**WELWYN HATFIELD BOROUGH COUNCIL
ASSISTANT DIRECTOR (PLANNING)**

Application No: 6/2023/1500/HOUSE
Location: 16 Brockwood Lane Welwyn Garden City AL8 7BG
Proposal: Erection of single storey rear extension, alterations and extension to rear dormer windows, insertion of rooflight into existing rear extension, installation of air conditioning unit.
Officer: Ms Louise Sahlke

Recommendation: Refused

Drawing No: 5753-P01 Revision: E

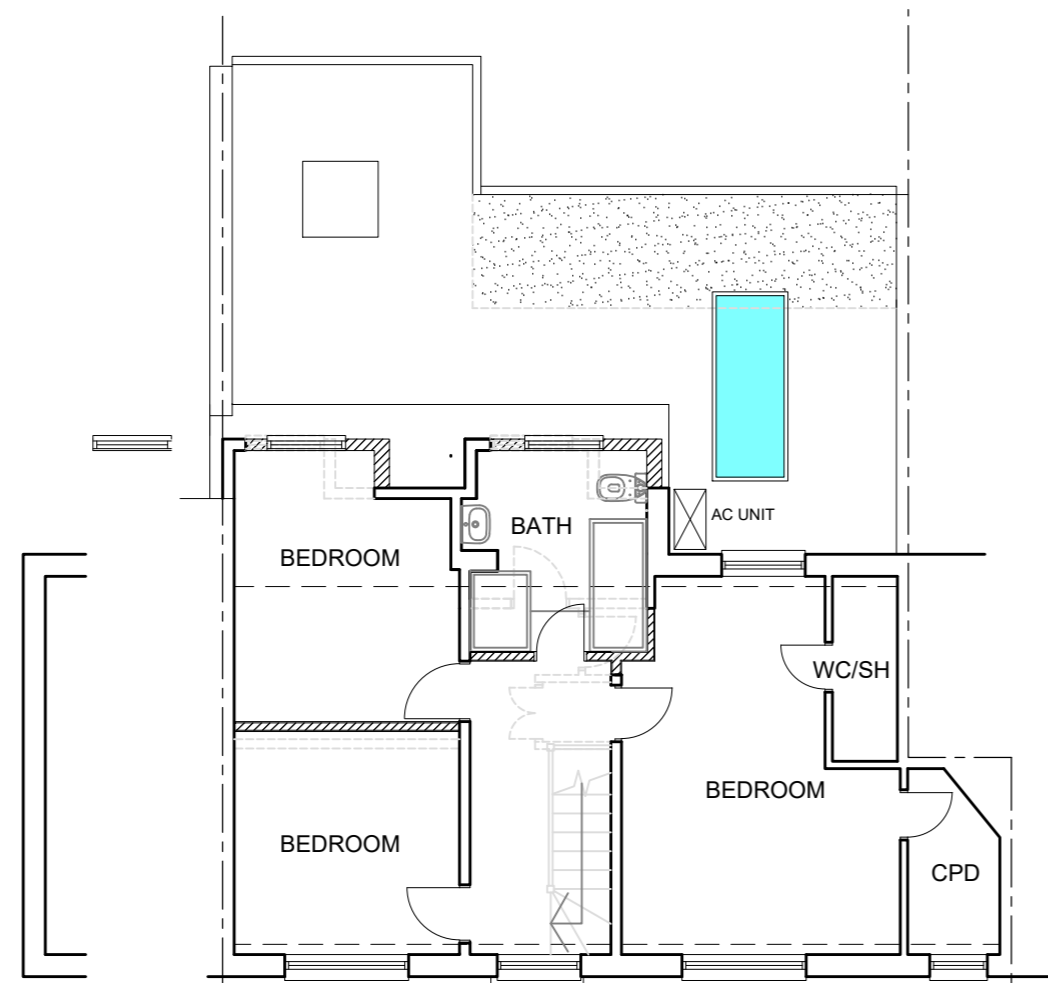
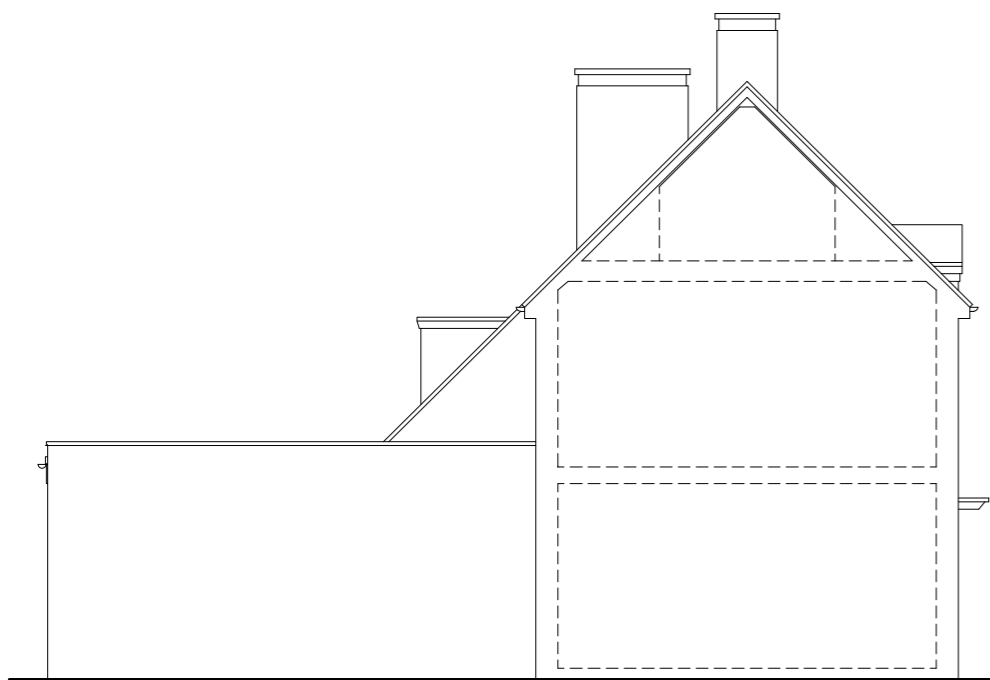
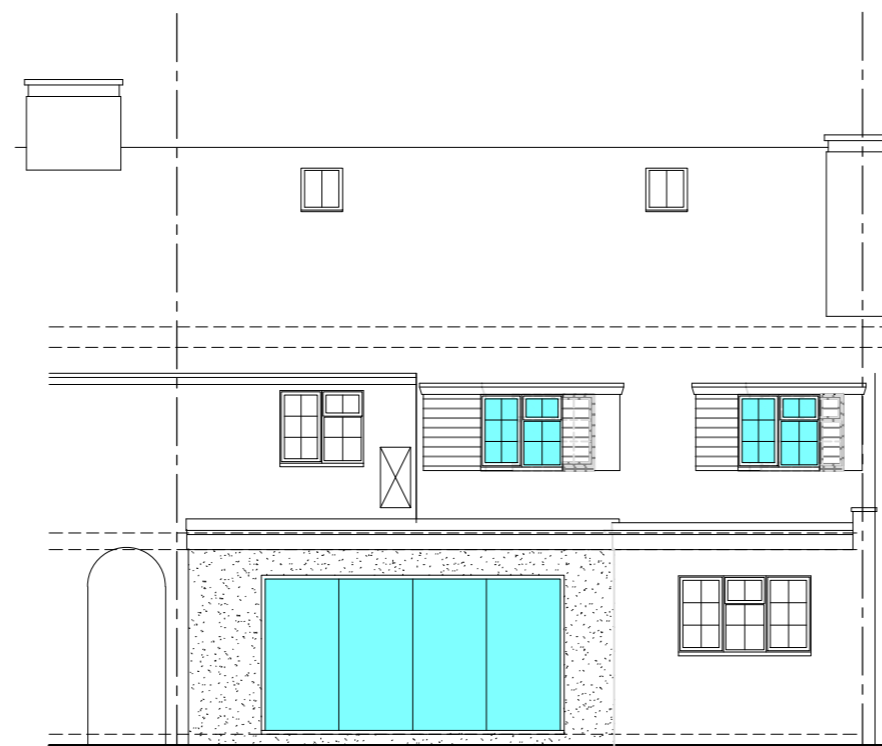
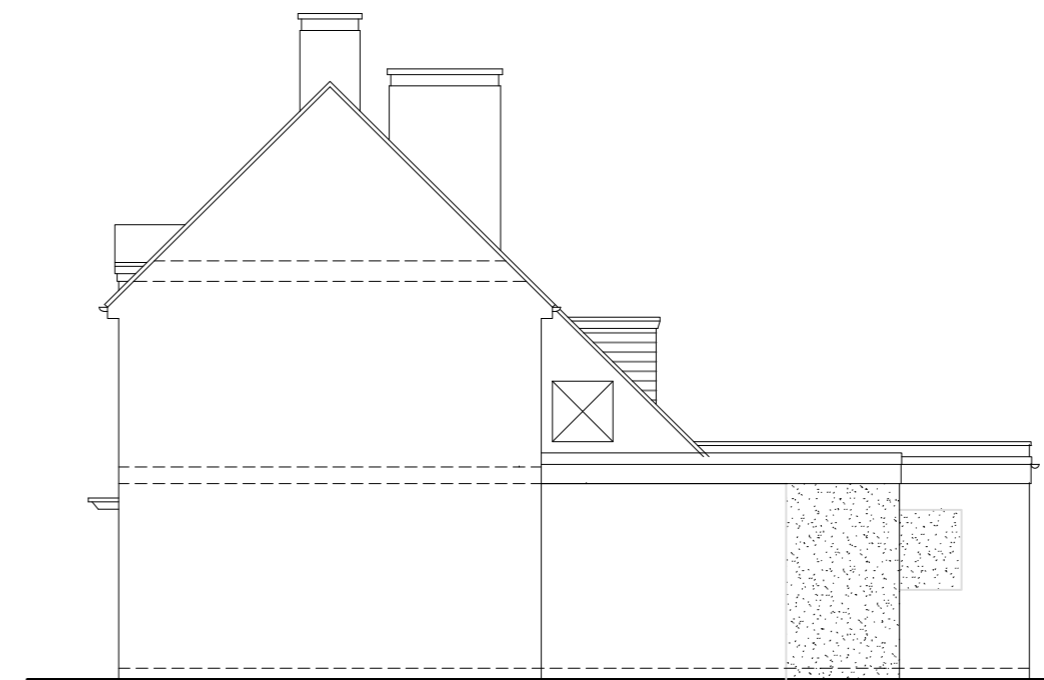
The proposed air conditioning unit would be utilitarian in design. The supporting information states that it would be approximately 80 x 70 x 40cm in size and the proposed elevation/floor plan demonstrates the design would be located on the side of the existing cat slide roof.

The proposed rear extension seeks to extend an existing extension by infilling an existing gap. The proposed rear extension would extend the existing rear extension by a proportionate 1.5 metres in depth and extend across the width of the whole property. The height of the rear extension would be maintained as existing. However, in combination with the existing depth of the rear extension, the overall depth would be approximately 5 metres in depth.

The proposed rear extension by virtue of its bulk, size, and massing, would fail to be a subservient addition at approximately 5 metres in depth from the original rear elevation of the dwelling. Therefore, it is considered that it would not respect the character and appearance of the existing dwelling or the terrace to which it is situated. This combined with the other elements of the proposal is considered poor design within the Conservation Area.

The proposed windows panes are broadly in proportion to the existing fenestration of the property, albeit not fully aligned. However, the proposed dormer windows would be larger than the existing dormer windows on the first-floor level in regards to height by 0.2 metres and width (by 0.6/0.7 metres). The combination of the larger sized dormers and the position of the left hand dormer window on the existing cat slide roof increases their prominence within the roof space. They would also be disproportionate to one another, due to

<p>their different widths.</p> <p>The proposed rear dormer windows, by reason of their bulk, size, and massing, would result in a cluttered appearance which fails to relate to or complement the existing extensions to the roof form and as such would conflict with the position of the existing dormer by extending to the edge of the existing cat-slide roof in situ. They would also fail to comply with all of the requirements of the SDG.</p> <p>The proposed development would result in less than substantial harm to the Conservation Area. Consequently, Paragraph 202 of the NPPF requires this harm to be weighed against the public benefits of the proposal. No public benefits have been identified which would overcome the identified harm. When weighed against the great weight afforded by the NPPF to the conservation of heritage assets, it is not considered that any identified benefits of the development would outweigh the harm caused to the significance of the Conservation Area.</p> <p>Accordingly, the proposal fails to preserve or enhance the character or appearance of the Conservation Area. In this respect, the proposal is contrary to Emerging Policies SP15 and SADM11. The development also fails to comply with the conservation requirements of the NPPF and Section 72 of the Planning (Listed Building and Conservation Areas) Act 1990. There is additional conflict with District Plan Policies GBSP2, D1 and D2 and Emerging Policy SP9 in so far as these policies only permit development of high quality design which maintains the character and appearance of the area.</p>

1. The proposed rear extension would fail to be a subservient addition at approximately 5 metres in depth from the original rear elevation of the dwelling. Therefore, it is not considered to respect the character and appearance of the existing dwelling or the terrace to which it is situated. The proposed rear dormer windows, by reason of their bulk, size, and massing, would also fail to complement or relate to the existing, more subservient and traditional design of the existing roof form, resulting in a cluttered appearance. The proposed development would therefore fail to respect the character of the dwelling or preserve or enhance the character and appearance of the Welwyn Garden City Conservation Area and would be contrary to Policies D1 and D2 of the Welwyn Hatfield District Plan 2005, the Welwyn Hatfield Supplementary Design Guidance 2005, Policies SP9 and SADM15 of the Welwyn Hatfield Draft Local Plan 2016, Section 72 of the Planning (Listed Buildings and Conservation Areas) Act 1990 and the National Planning Policy Framework.
